Stage 1 Road Safety Audit Designer's Response

Report Title:	Stage 1 Road Safety Audit Designer's Response – Proposed Site Access, Hemingfield Road, Hemingfield
Date:	21 st August 2024
Document Reference and Revision:	23-160-006.03
Prepared by:	Bryan G Hall Limited
On behalf of:	Barnsley Metropolitan Borough Council (Overseeing Organisation)

This Stage 1 Road Safety Audit Designer's Response has been prepared by Bryan G Hall Limited to address the points raised in the Stage 1 Road Safety Audit of the proposed vehicular access junction with Hemingfield Road, to serve a proposed residential development. The Stage 1 Road Safety Audit was carried out by Bryan G Hall Limited and is dated 15th July 2024 (report reference no. 23-160-005.01).

Drawing No: 23/160/ATR/003

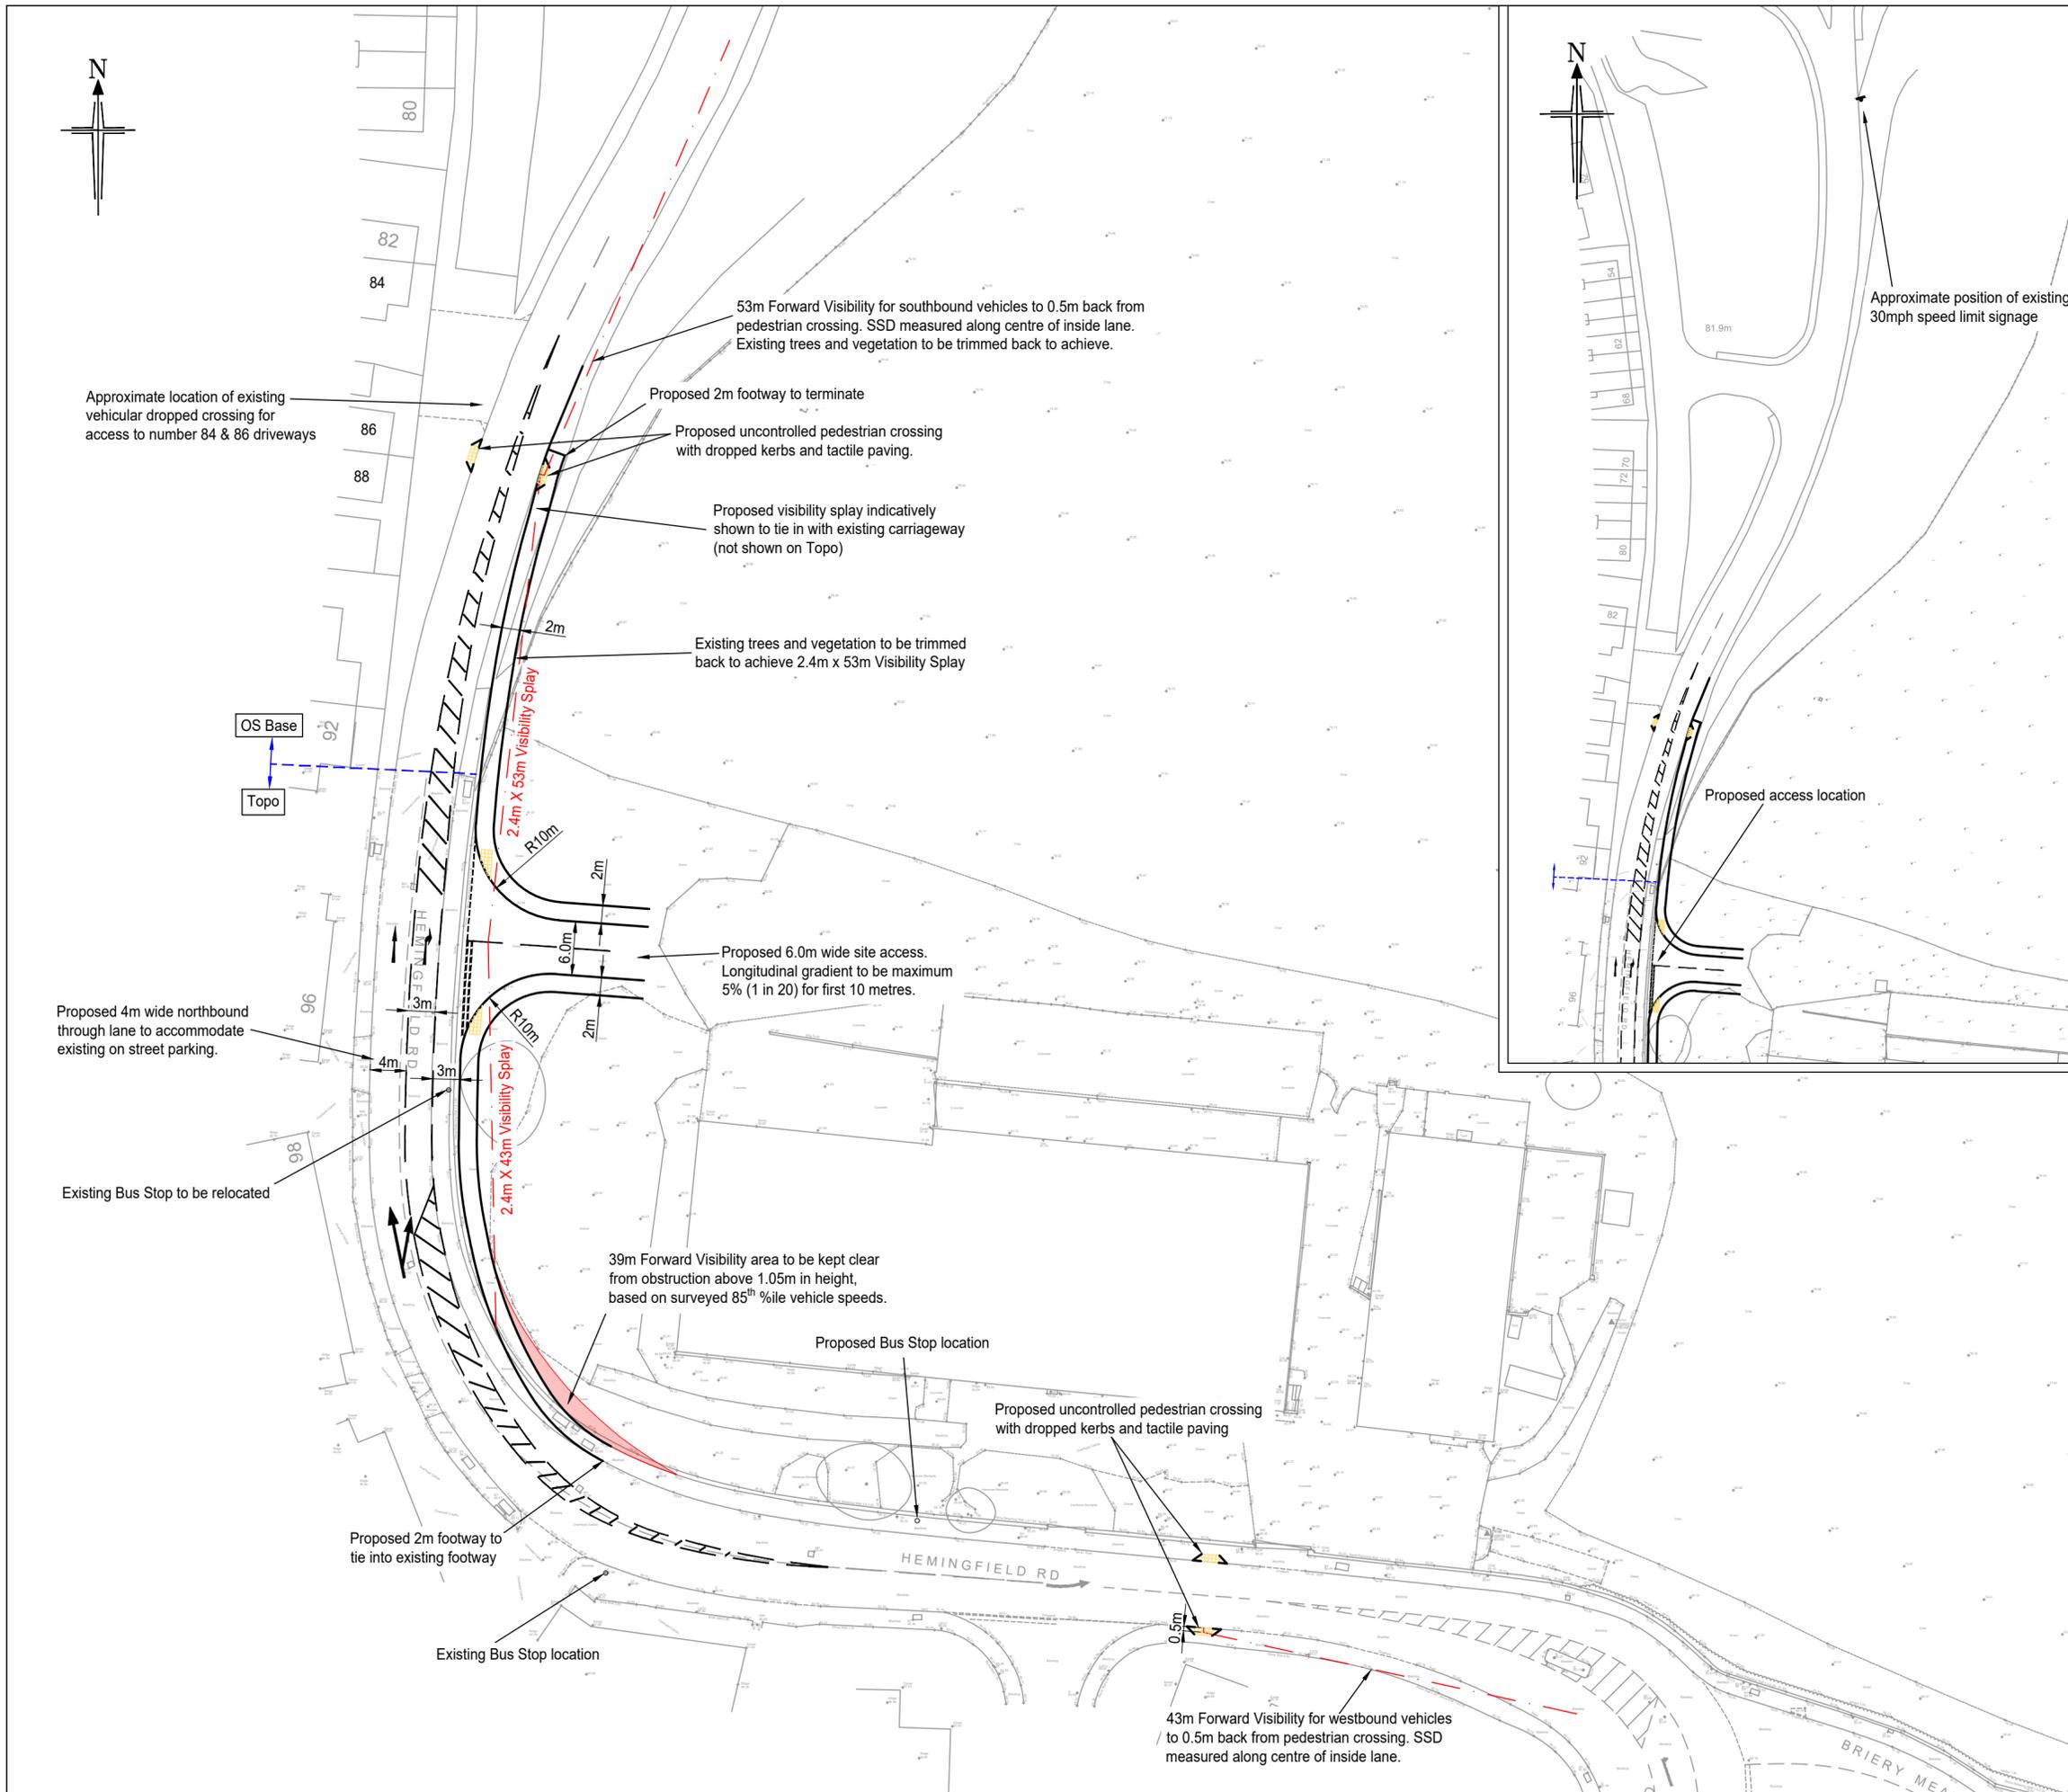
Problem H				
Hemingfield Road southbound through lane width.	It is recommended the southbound movement through the junction is assessed further to ensure that large vehicles including buses can pass through	Swept path analysis of a single deck bus and a 16.5 metre articulated HGV travelling southbound along Hemingfield Road has been undertaken, as shown on drawing number 23/160/ATR/003 Rev A at Appendix BGH2 .

RSA Problem	RSA Recommendation	Design Organisation Response	Overseeing Organisation Response	Agreed RSA Action
	the junction safely without encroaching on the right turn pocket associated with the proposed access.	<p>BMBC have requested that a 0.5 metre clearance from the kerb line is provided for swept path analysis, therefore this has been reflected.</p> <p>The swept path analysis shows that both vehicles can pass southbound through the proposed junction without encroaching into the area of the right turn ghost island where vehicles may be waiting to turn right into the site. Whilst there is a very slight encroachment into the entry side of the ghost island, this is exaggerated by the 0.5 metre kerb clearance shown on the swept paths, as in reality, vehicles would be travelling more centrally within the southbound lane.</p> <p>Full height kerbs will be provided along Hemingfield Road, in the vicinity of the site access to provide added protection for pedestrians along the footway.</p>
